## Department of Transportation

March 26, 2021

RE: Helton Amended Site Plan - South Academy Business Park\_ SH85.87

SECTION E-E
SCALE: HOR 1" = 10', VER 1" = 5'

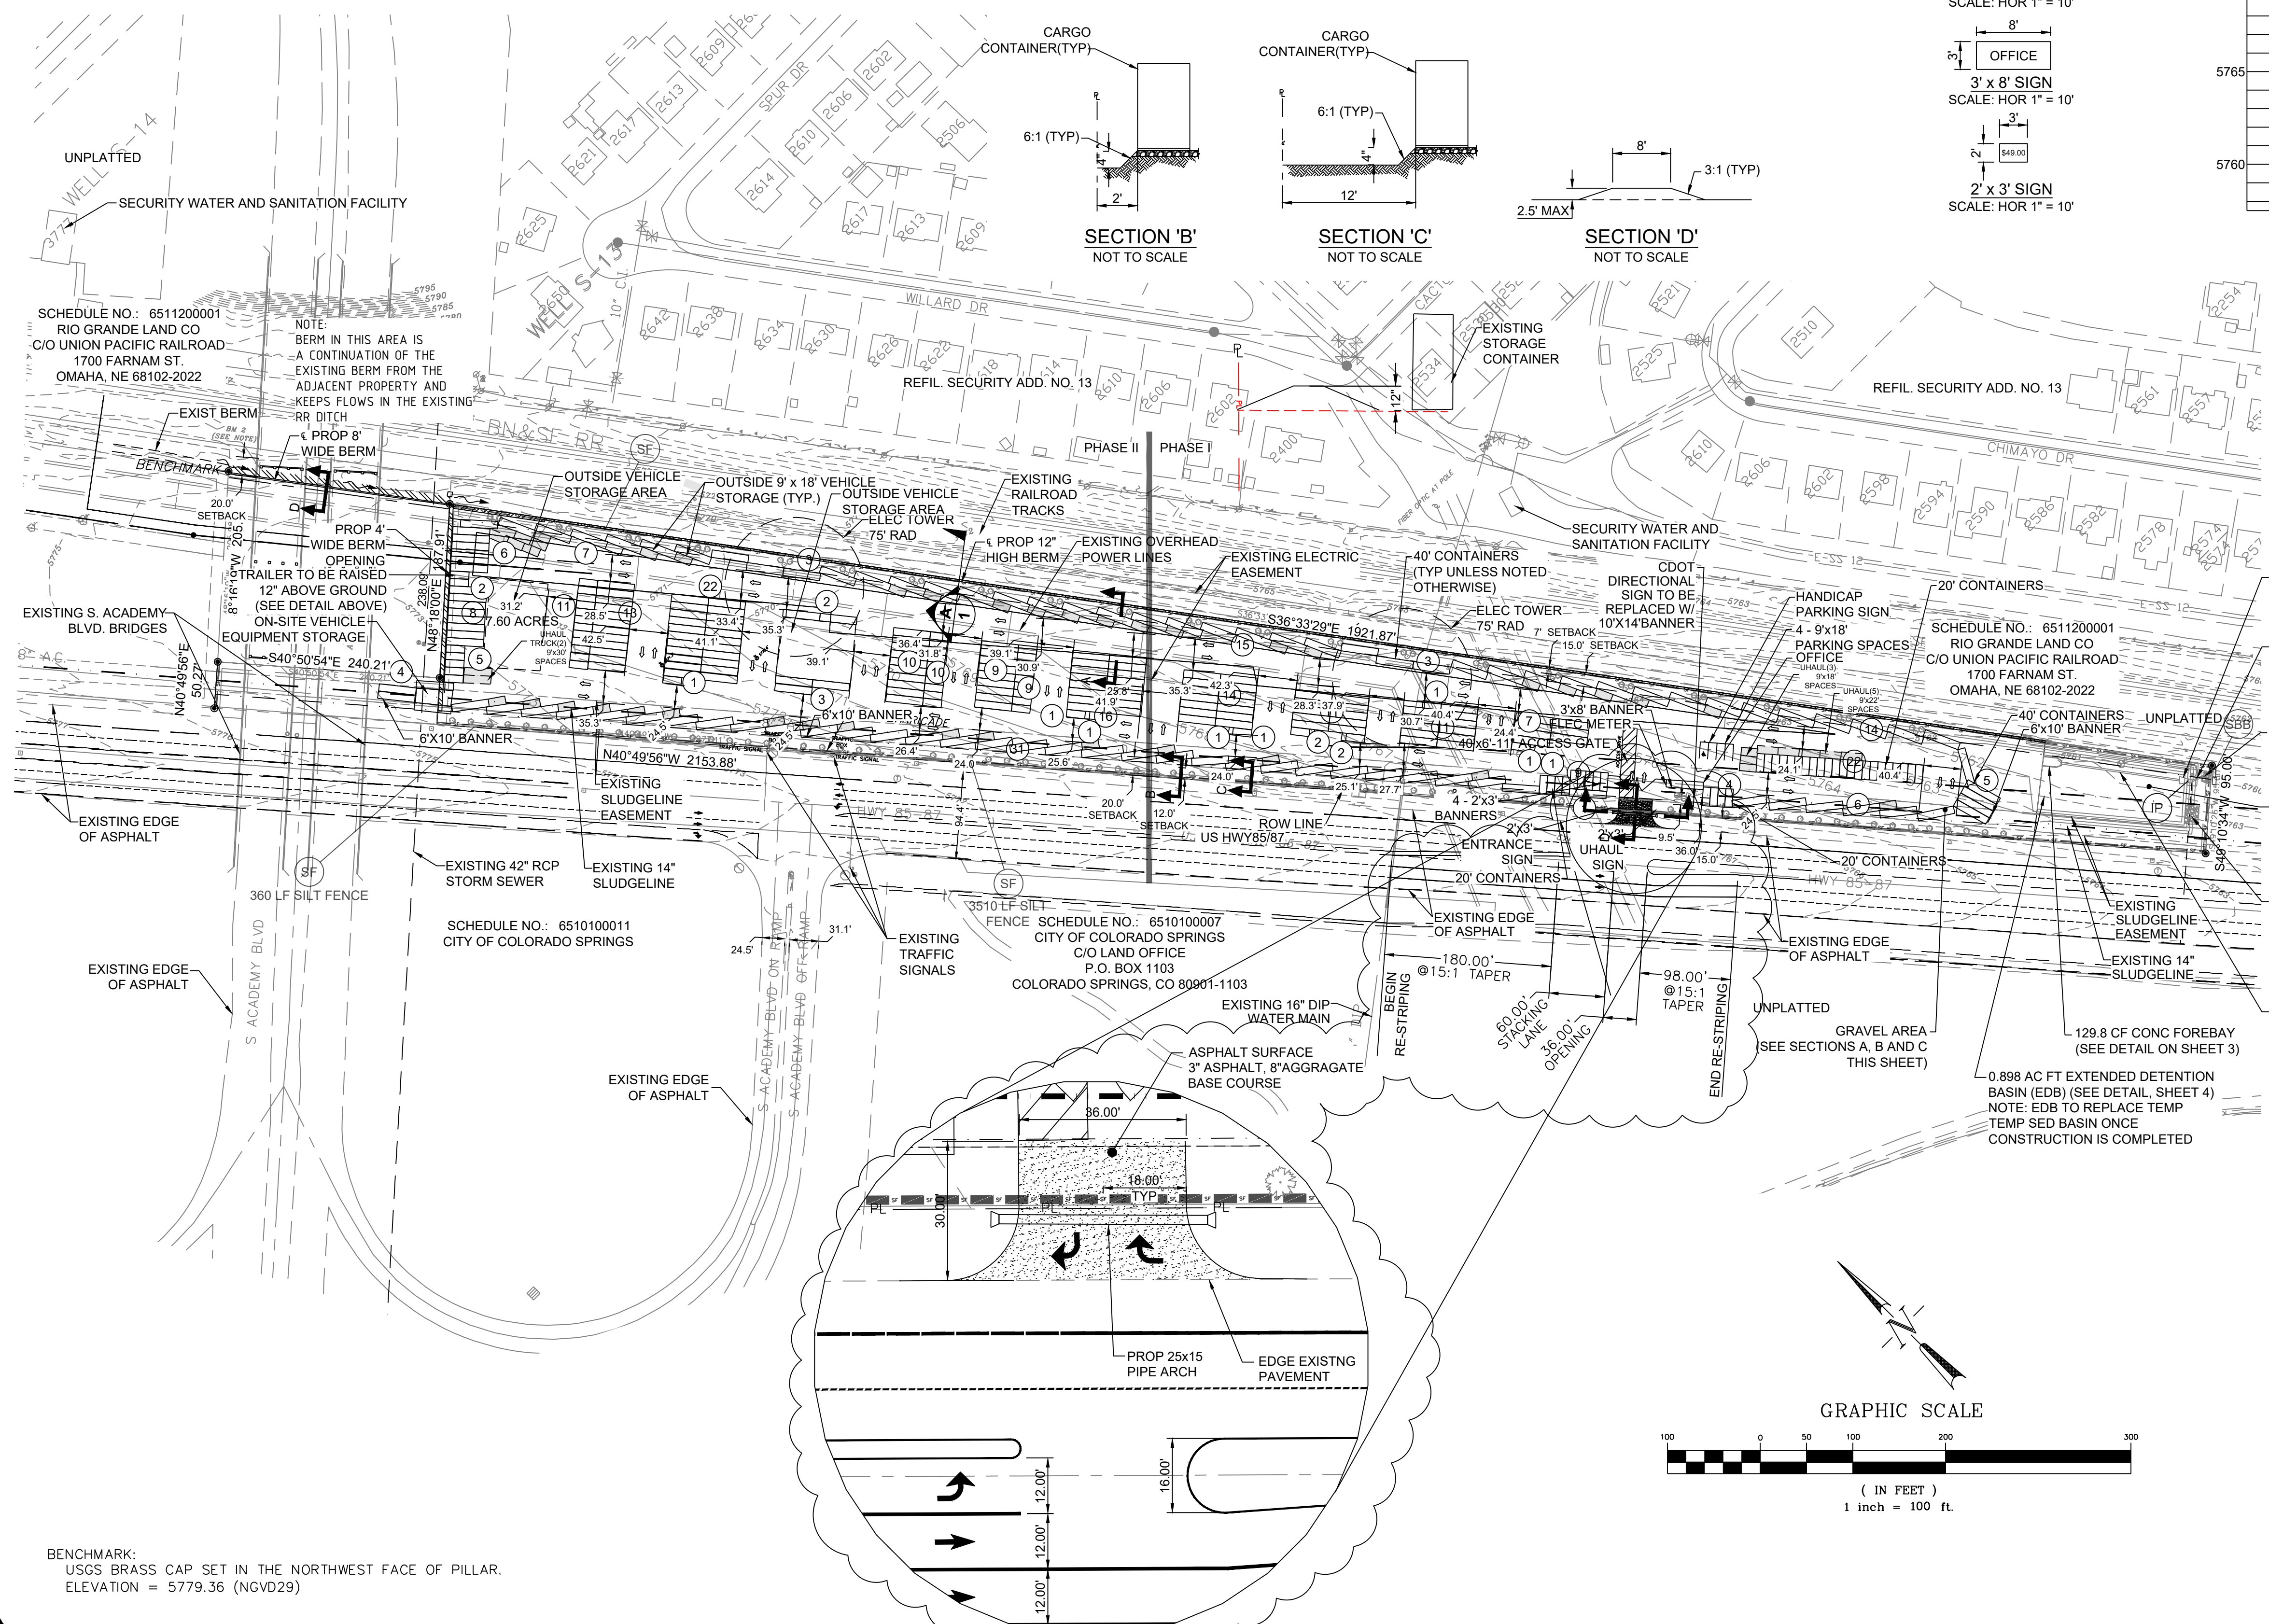
- CDOT Access Dept. comments are as follows:
  - a. The developer is required to apply for a new Colorado Department of Transportation Access Permit to document the new roadway improvements proposed.
  - b. No additional access from SH85/87 will be permitted to the site.
  - c. Review of the acces permit AP218005 from CDOT mentions that Right In/Right Out traffic movements are the only allowable traffic movements until such a time of expansion or redevelopment which requires a new access permit, roadway improvements to SH85/87 and a centerline non-traversable median was required.
  - d. A more detailed roadway drawing or plan is being requested for review.
